Our Ref: R/2019/22/B
File No: 2021/128240
Your Ref: SSD 10382

Response to Submissions – Student Accommodation (SSD-10382) – 90-102 Regent Street, Redfern

Thank you for your correspondence dated 4 March 2021 requesting for the City of Sydney Council (“the City”) to comment of the Response to Submissions (RTS) for the abovementioned application for student accommodation at 90-102 Regent Street, Redfern.

1 DA GROUND (L1) FLOOR PLAN  
1:200

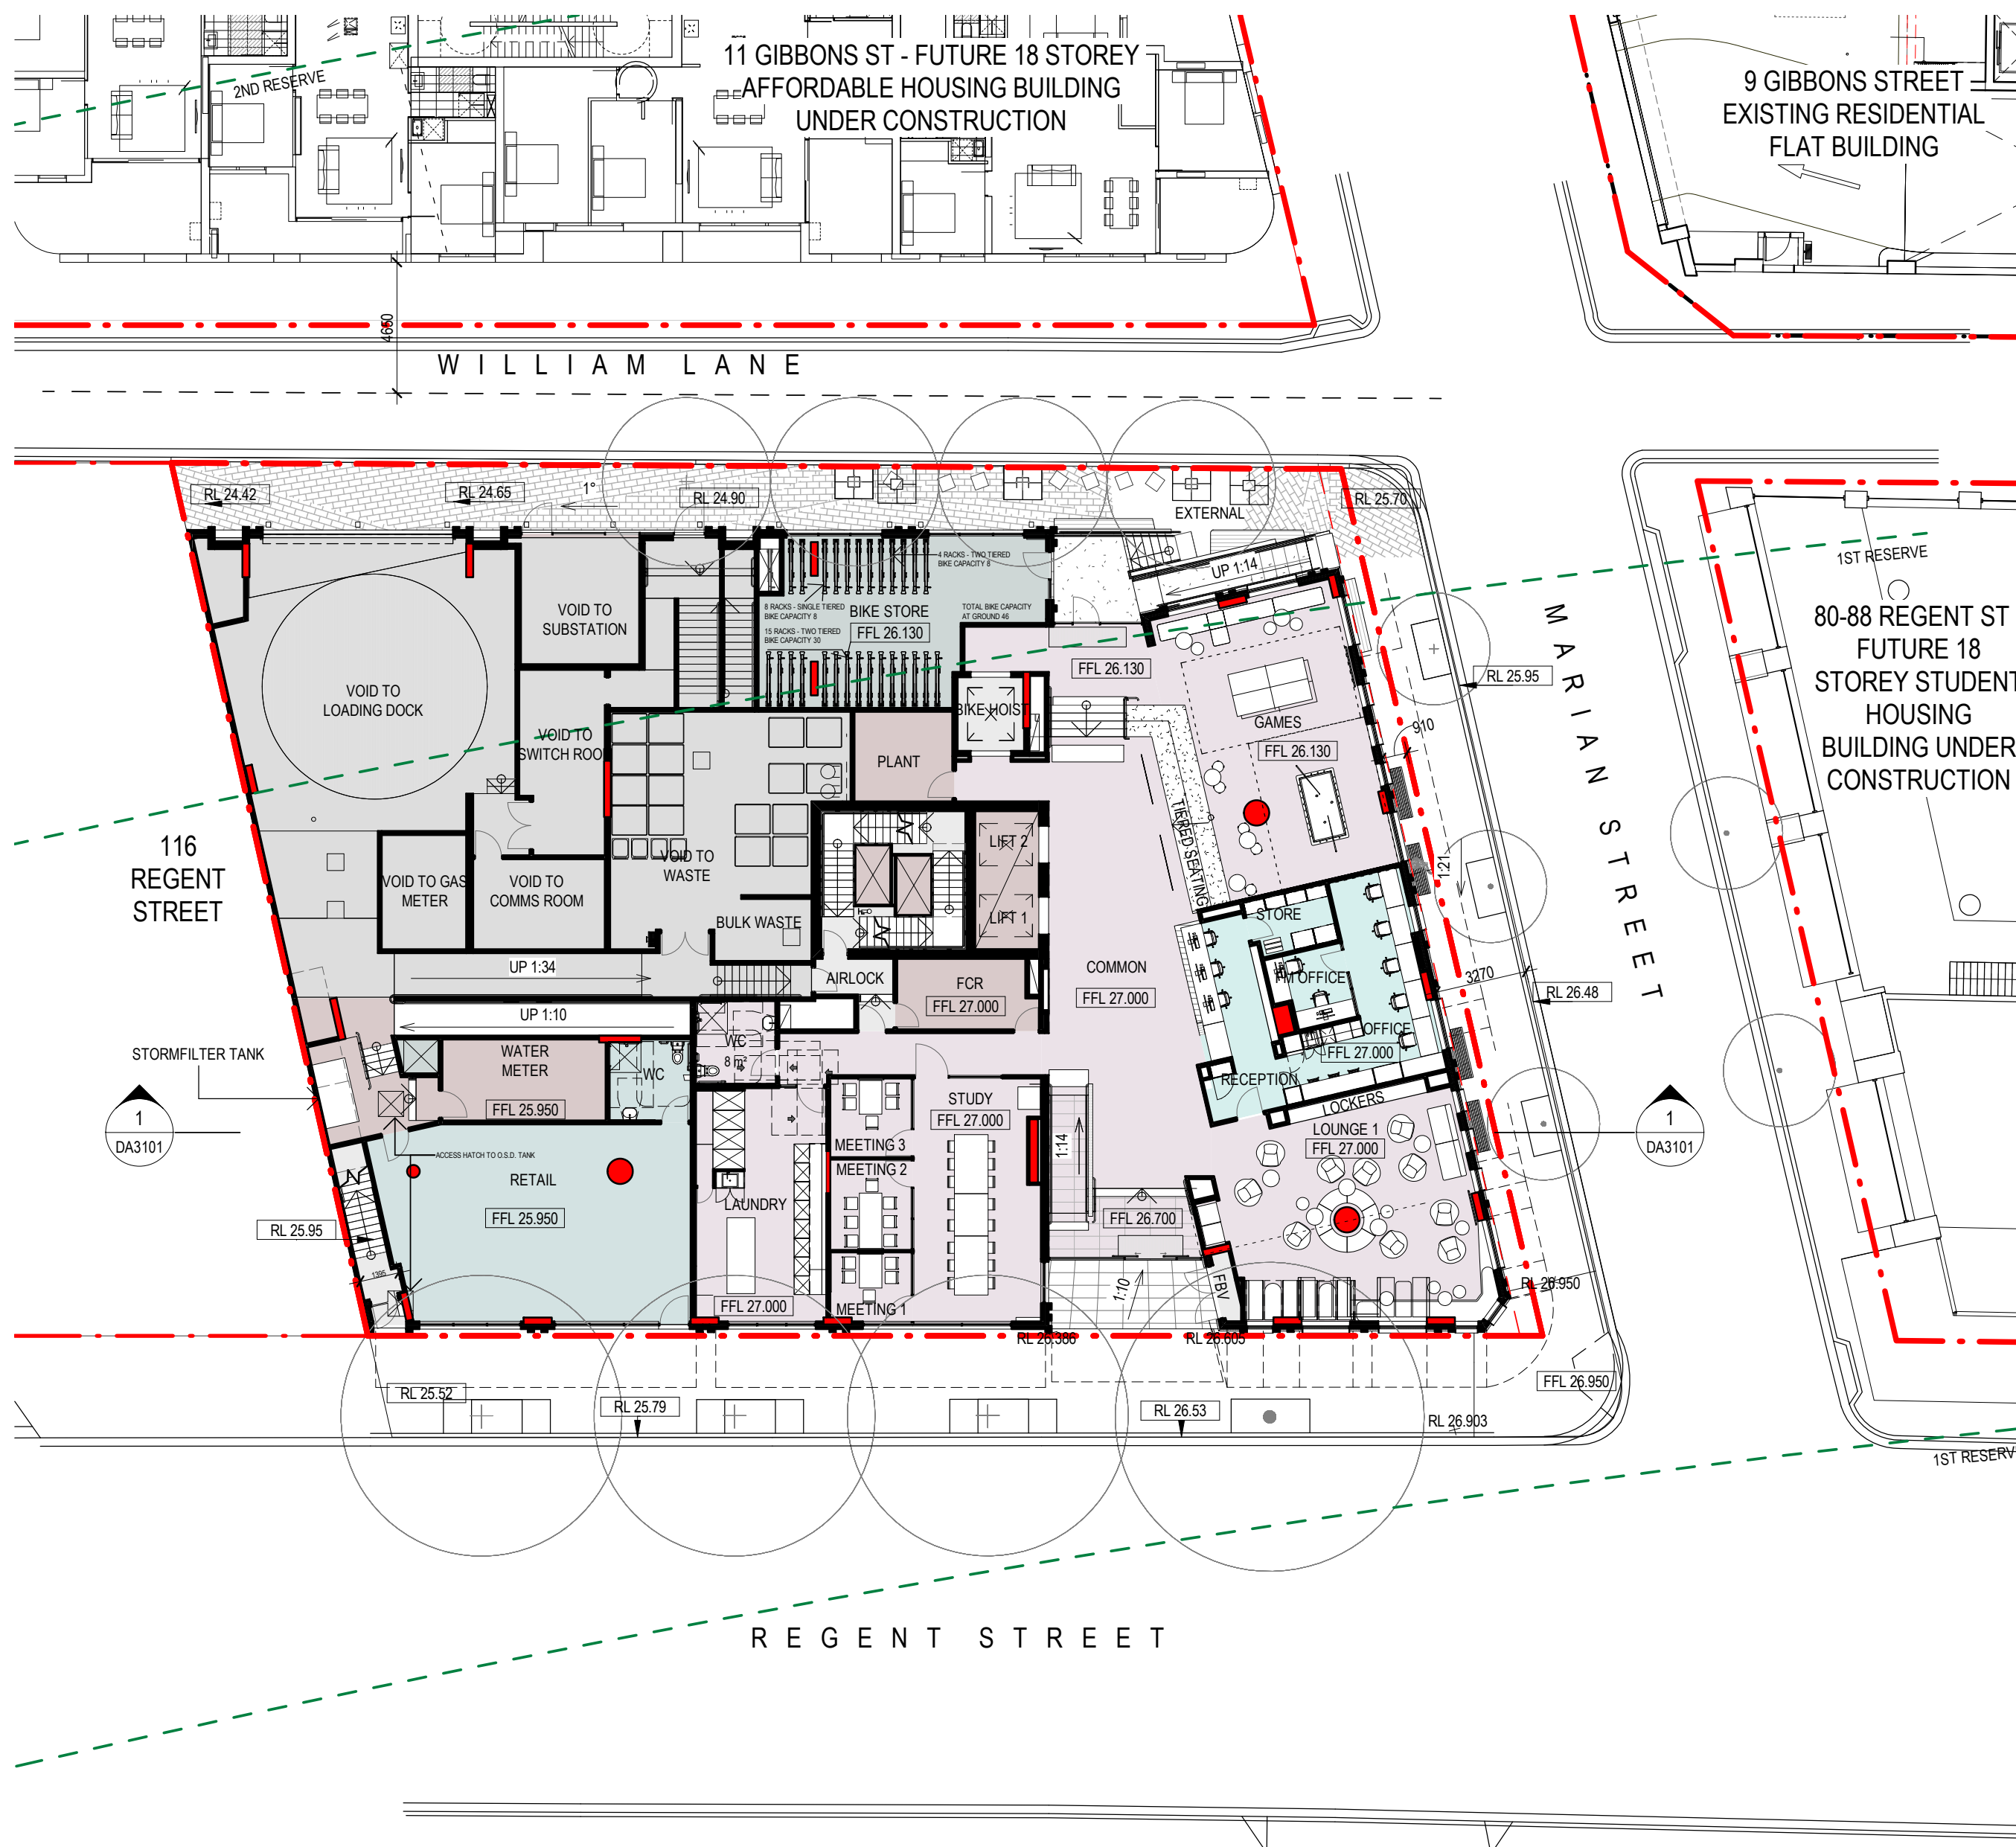
As previously raised, the proposed gaps in the awning and the width of the awning on Marian Street do not provide continuous and adequate weather protection. The RTS indicates that the gaps are required for the existing and proposed street trees. However, the submitted architectural plans demonstrate that the breaks in the awning do not correlate with the location of street trees.

More importantly, the finished floor levels and gradients of the development, notably the basement and loading bay entry and door openings as well as the finished floor levels of William Lane and footpaths must be indicated in the architectural floor plans. Overall, the finished floor levels of the development must comply with the Interim Flood Management Policy and Public Domain Manual.

2 LEVEL 2 PLAN  
1:200

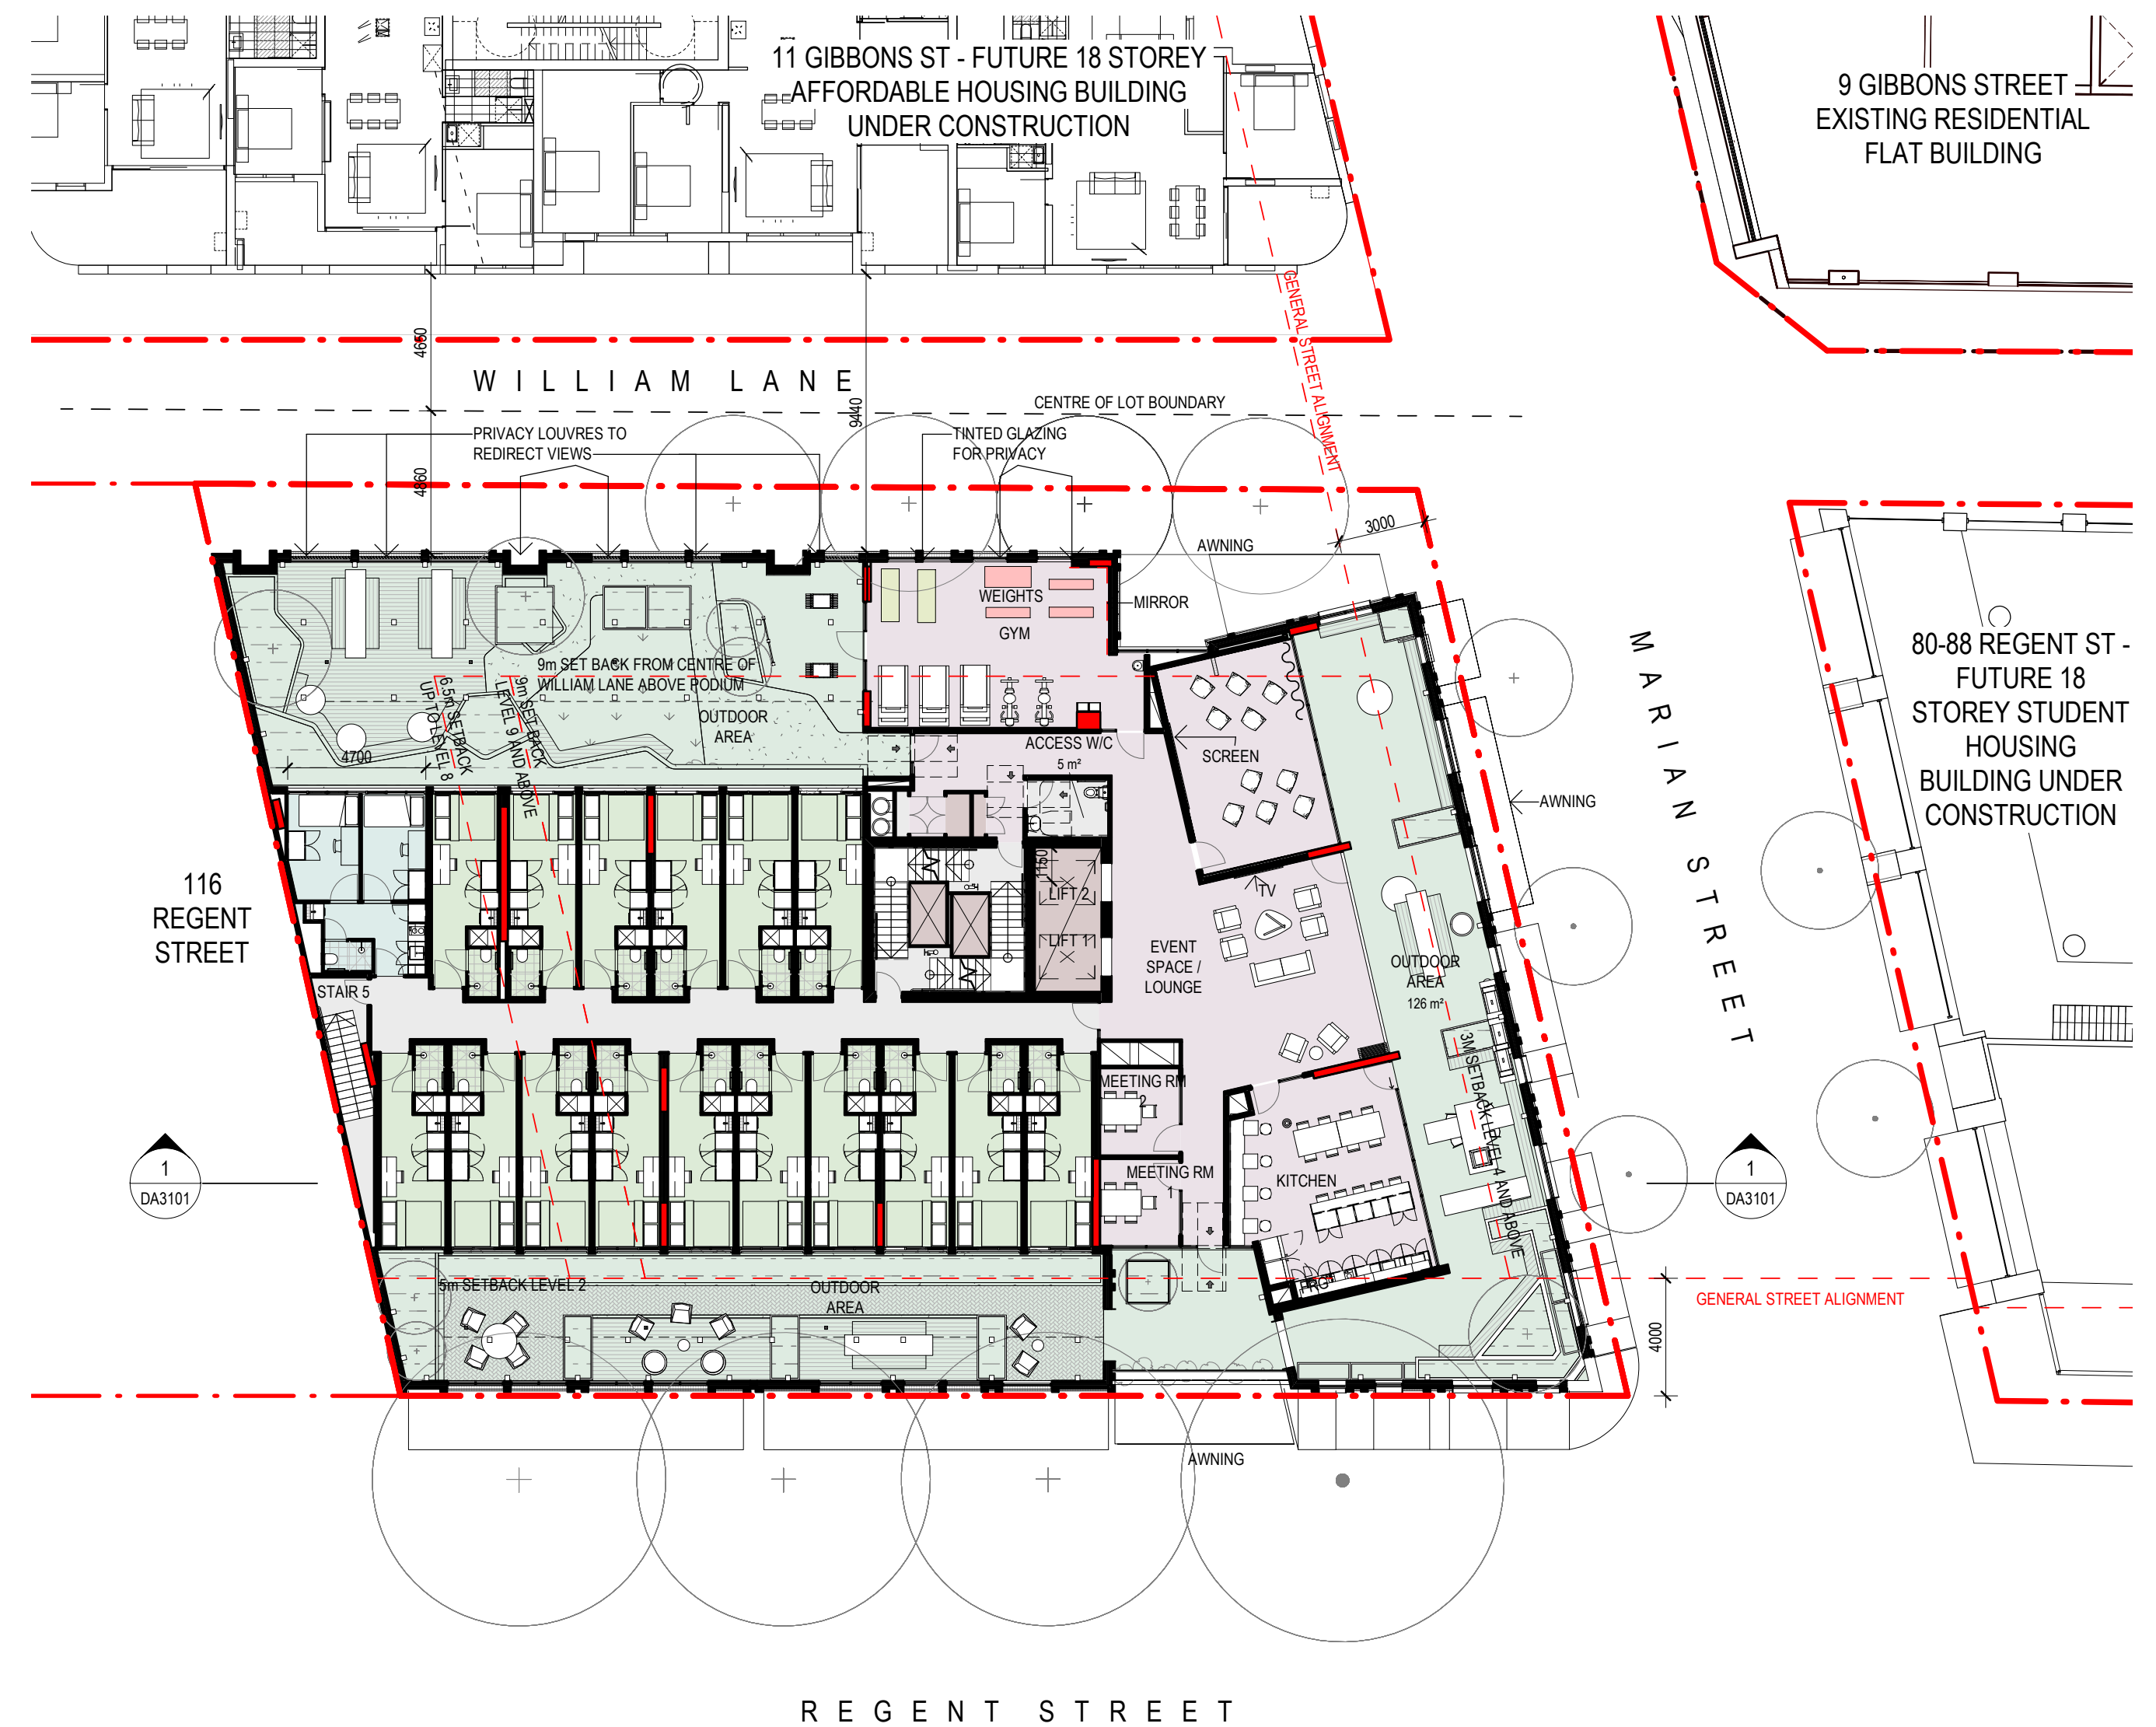
The common outdoor areas on the podium have become enclosed since the last iteration of the proposal, with an addition of a louvred awning for wind mitigation on the northern terrace. Similarly, the eastern and western terraces are now under glazed awnings. This could affect the amenity of the rooms adjacent to the eastern and western terraces in terms of reflected noise and lack of visual privacy. Additionally, these east and west terraces could become quite uncomfortable with heat being trapped under the glass awning.

The development could be improved if the rooms adjacent to the east and west terraces were common spaces similar to the north terrace. If this could not be achieved, the amenity and privacy of these rooms could be improved with a balcony in front of the rooms that act as a transition space between the east and west terraces and the internal rooms. Disconnecting the roof plane of the glass awning from the walls would also help release noise and heat gain and provide better air circulation in these spaces.

Changes on the Level 2 outdoor area include an enclosure of the common open spaces with glazed awnings and pergola for wind mitigation. However, this would impact on the provision of open space amenity and the success of new trees and landscaping on slab. Privacy and overlooking between communal areas and private habitable rooms is a concern on the eastern and western terraces.
